Scott Meredith
Tri-State Generation and Transmission Association
1100 W. 116th Ave.
Denver, CO 80233

June 19, 2024

This memo is to serve as an addendum to the original Vollmer Substation drainage report prepared by Terra Nova, dated January 31, 2022. This memo summarizes the design of a new extended detention basin to replace the existing sand filter and demonstrate compliance with El Paso County design requirements.

ORIFICE PLATE AND TRASH RACK
DETAILS AND NOTES

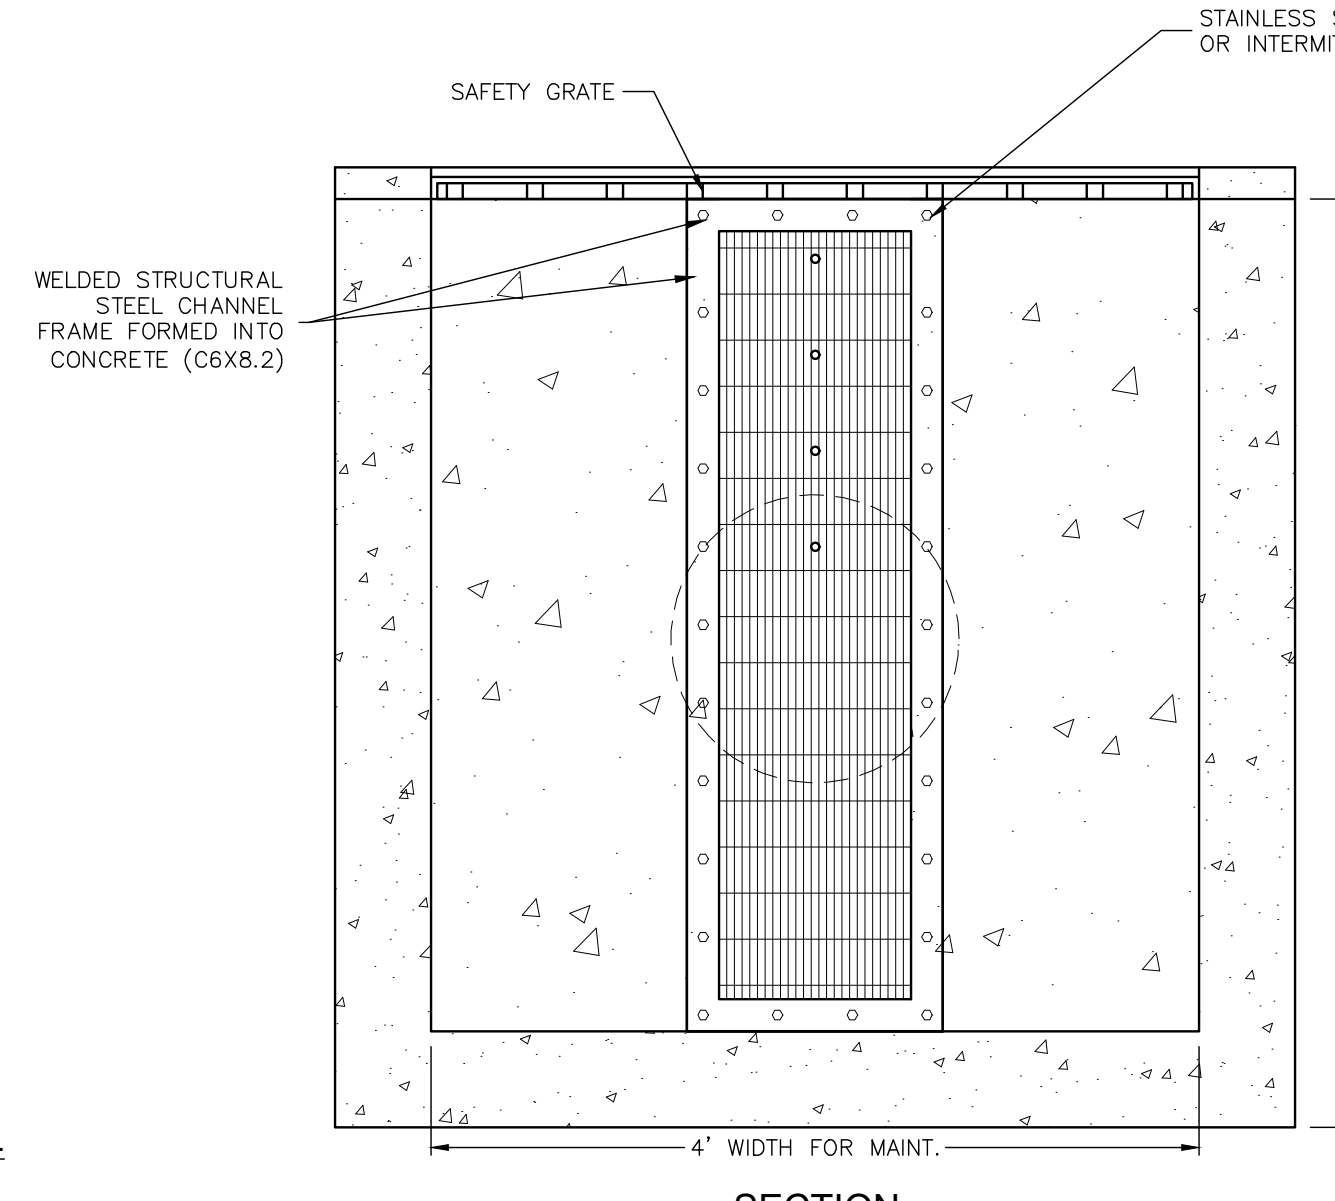
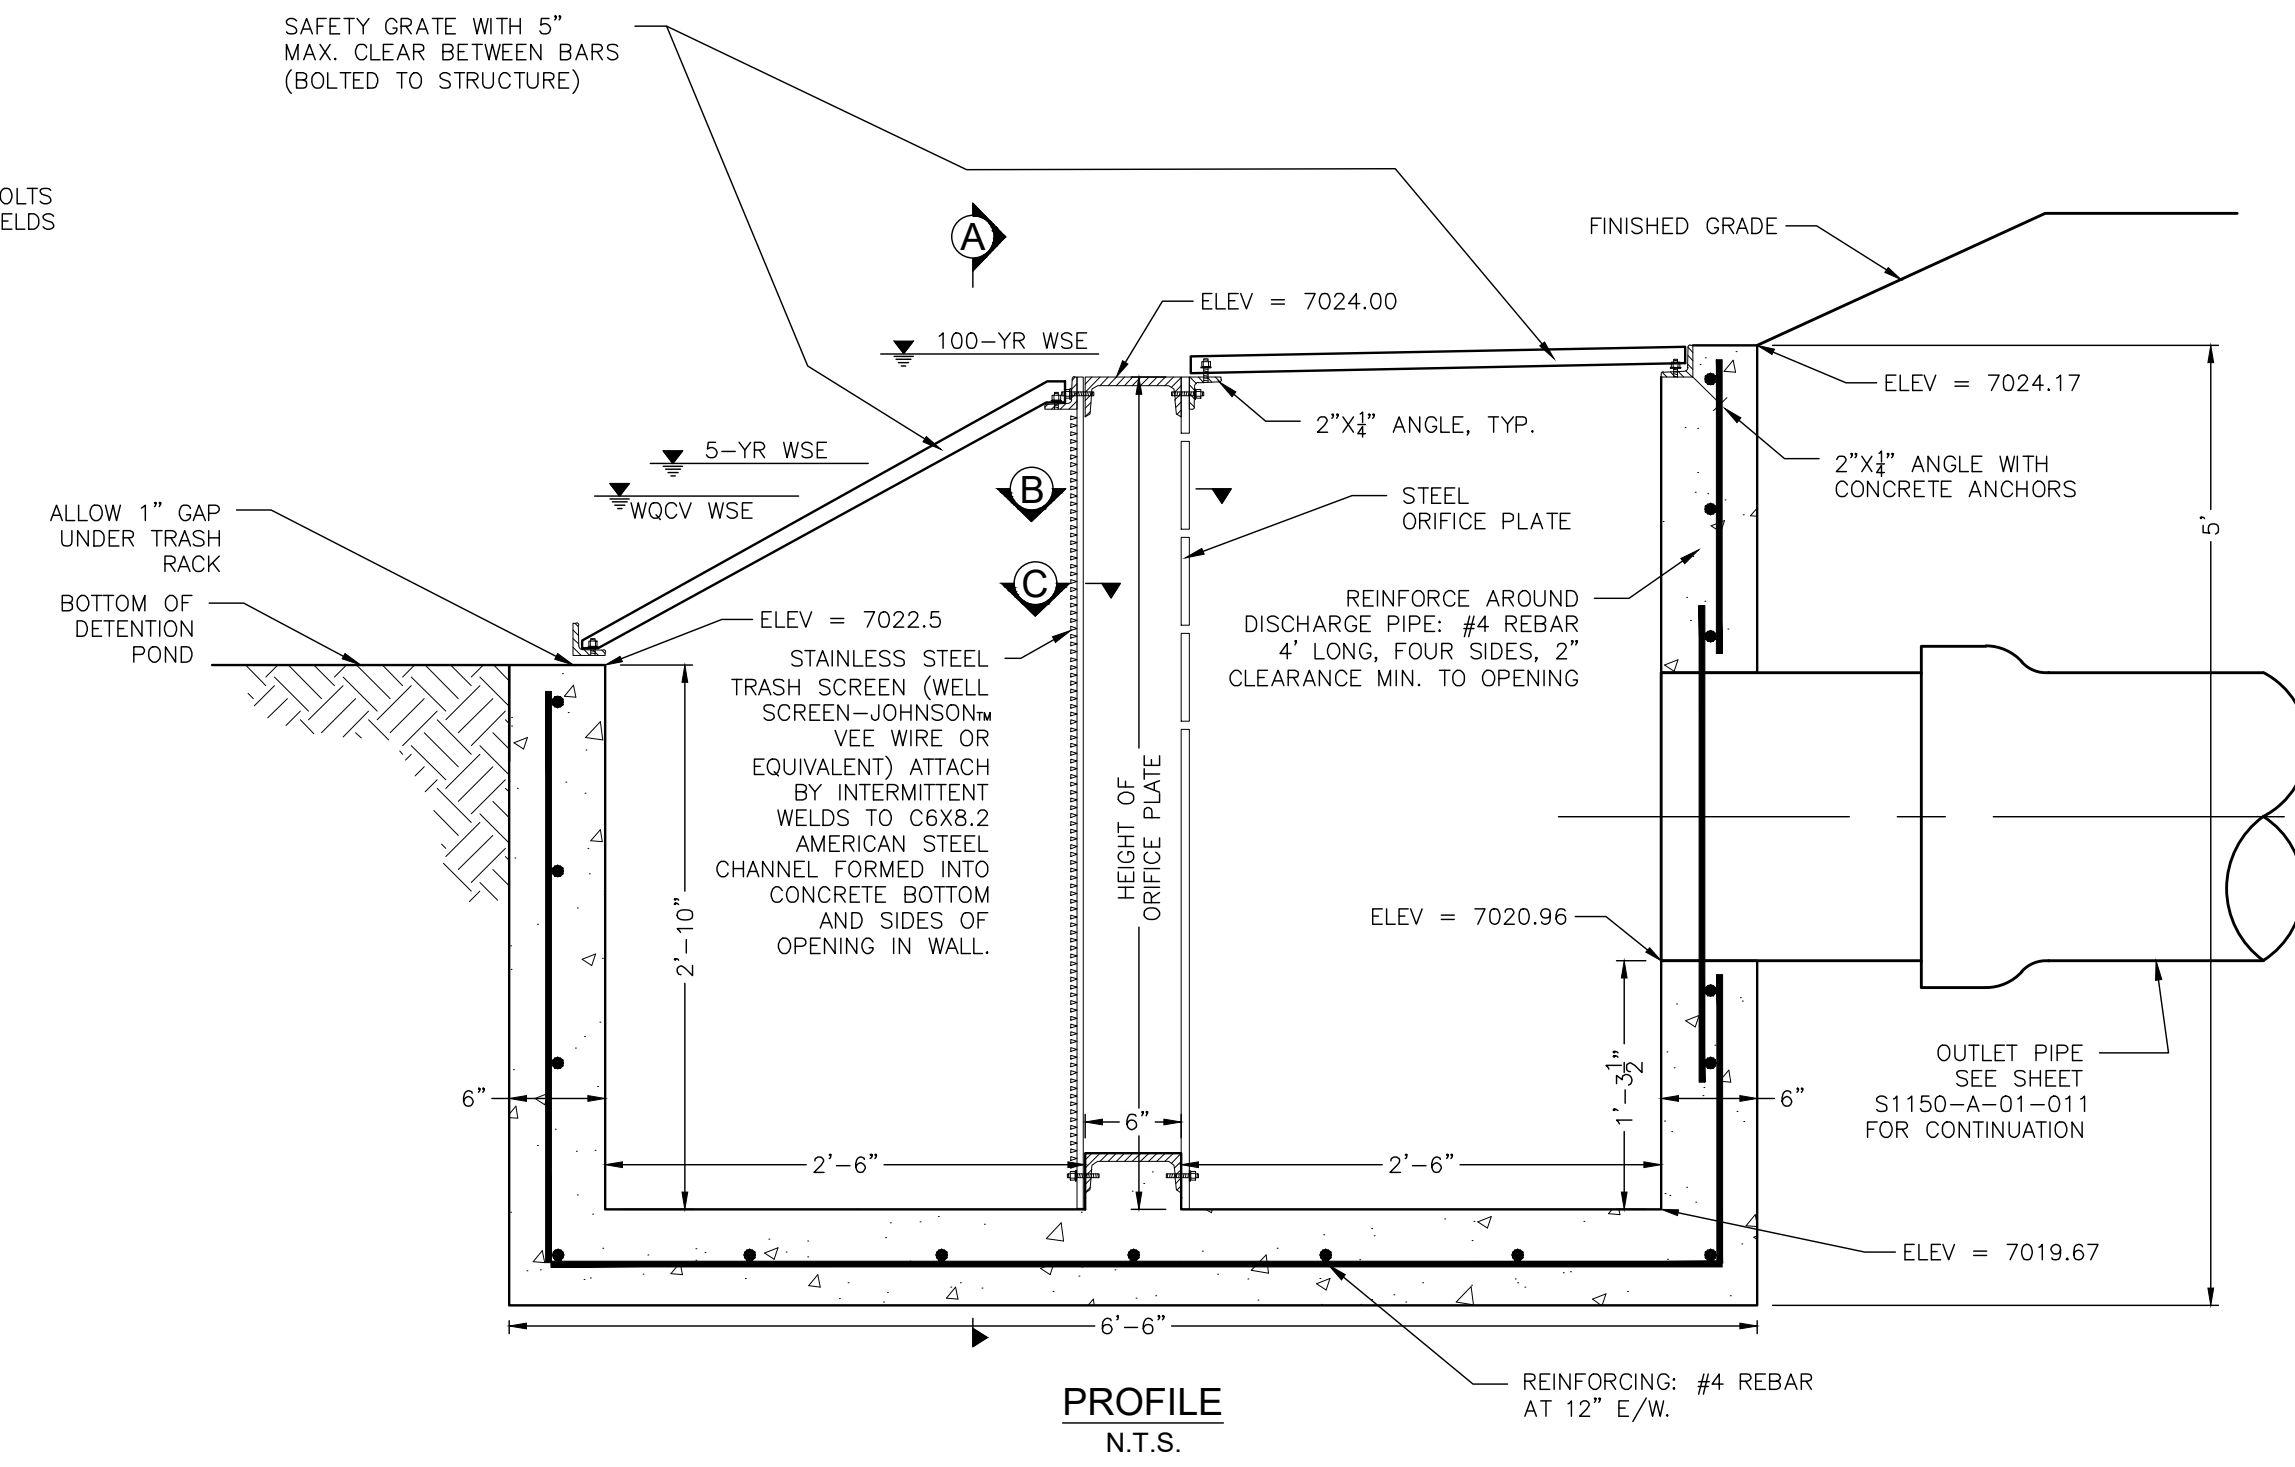
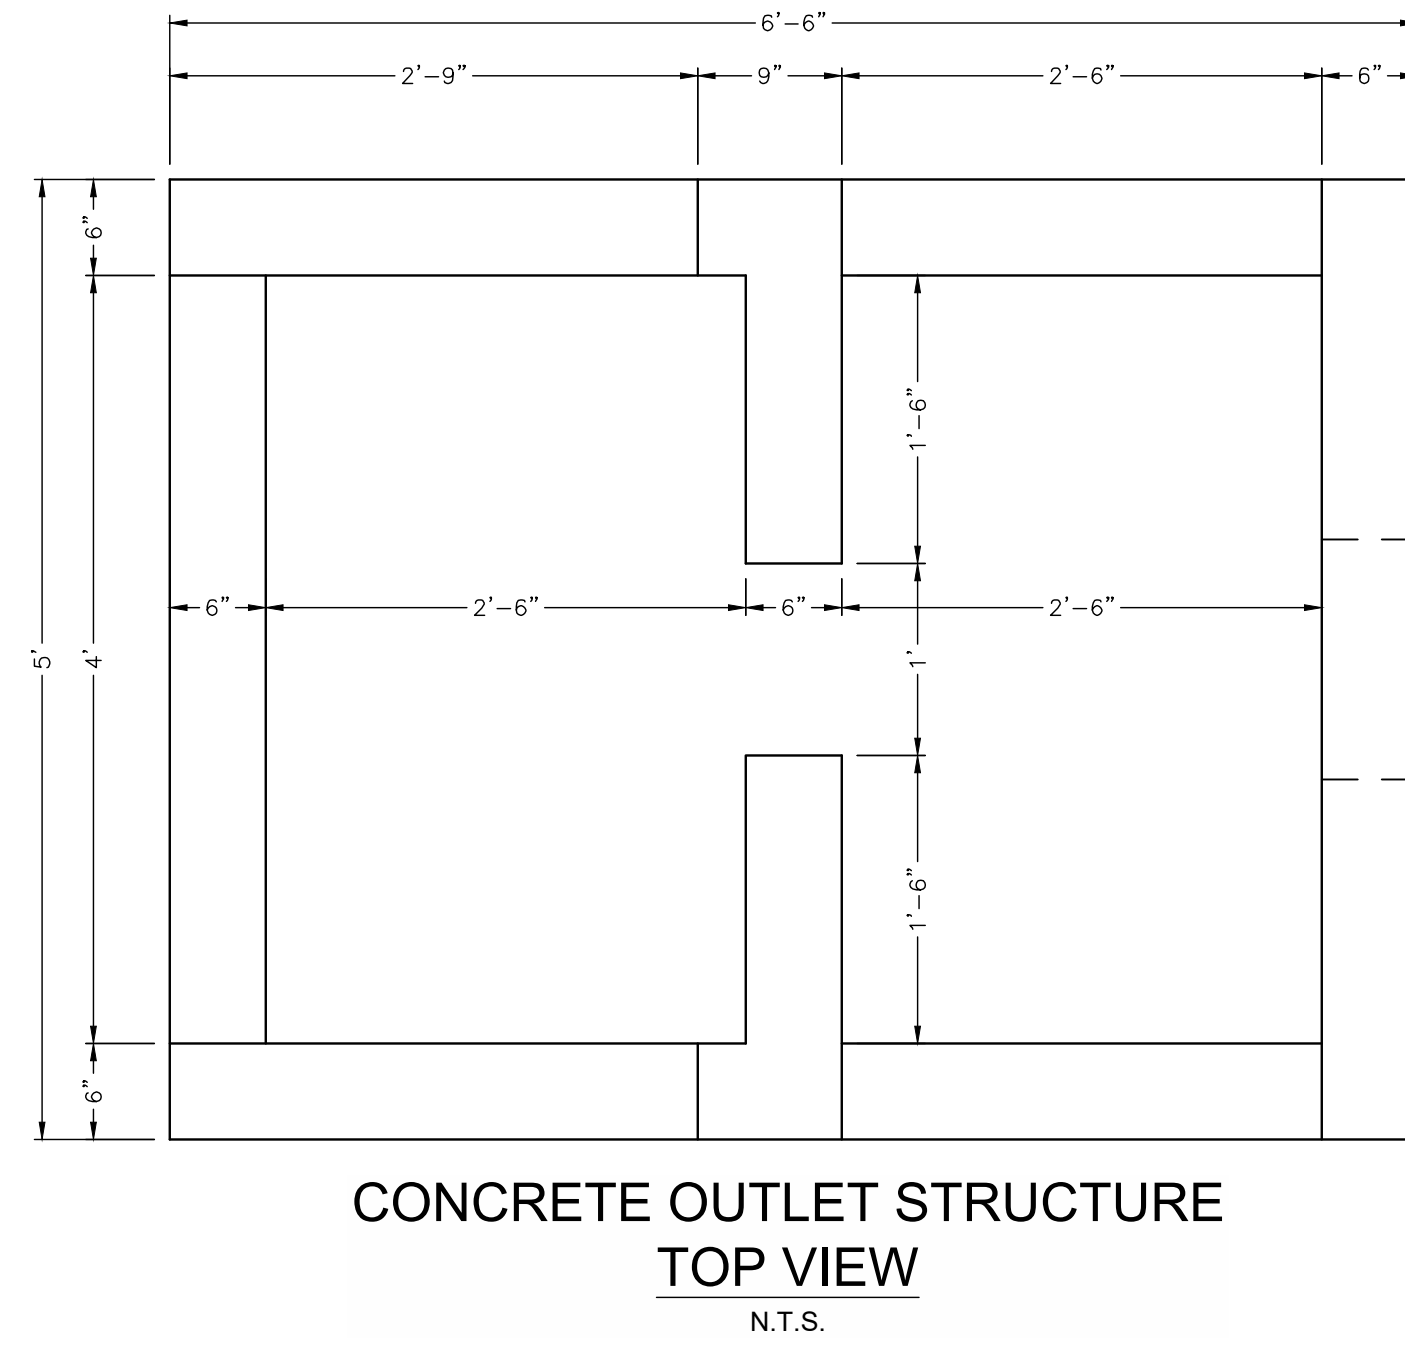
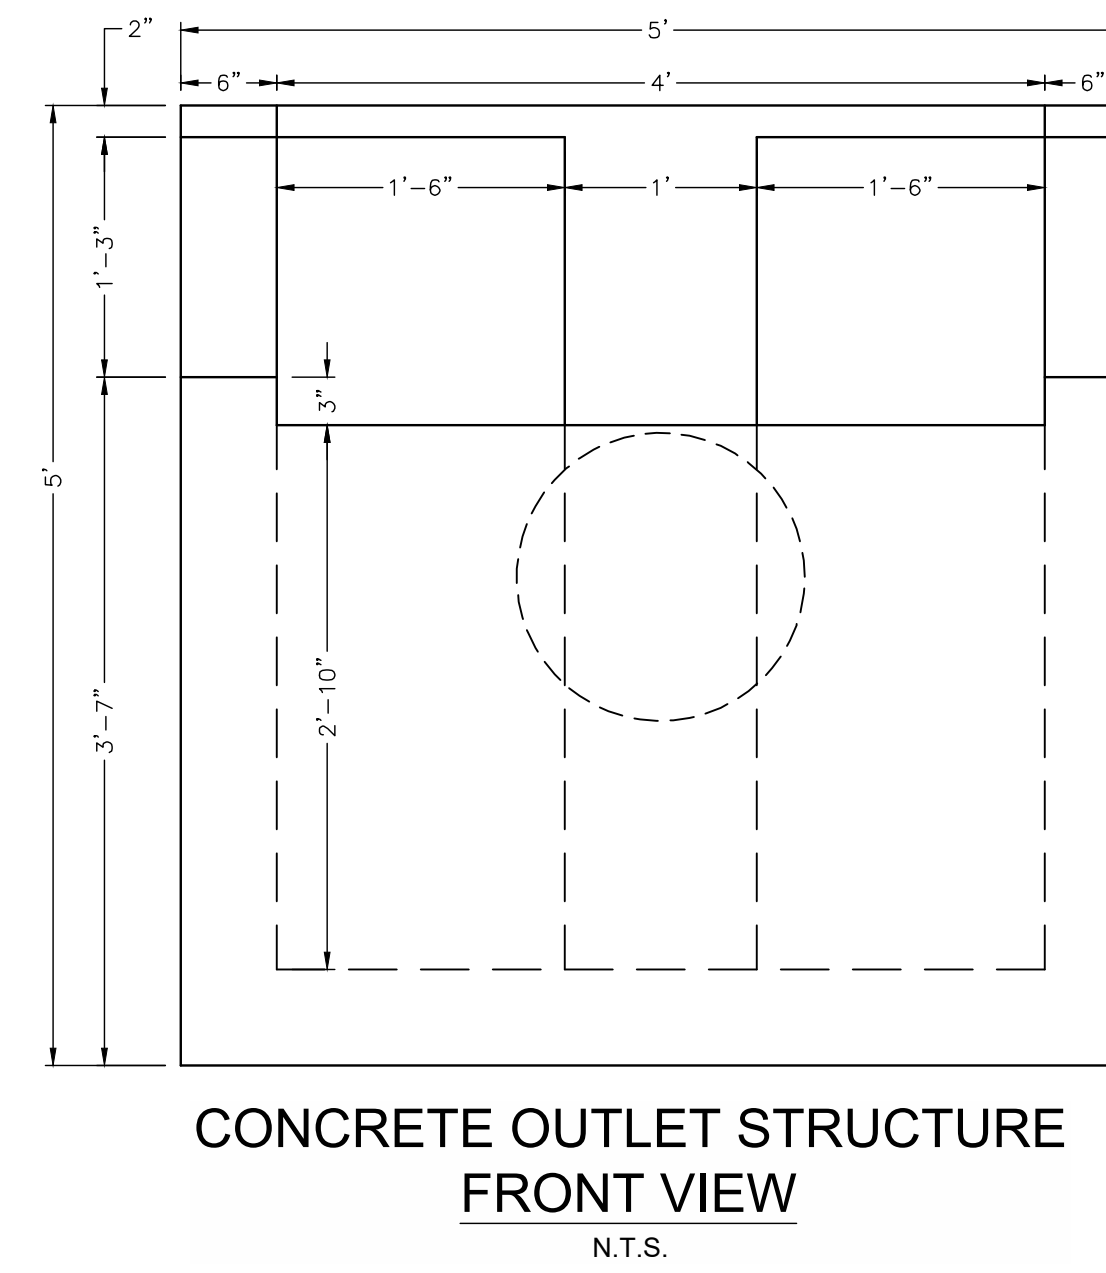
A spillway is necessary, please input values here and see my comment on the CDs
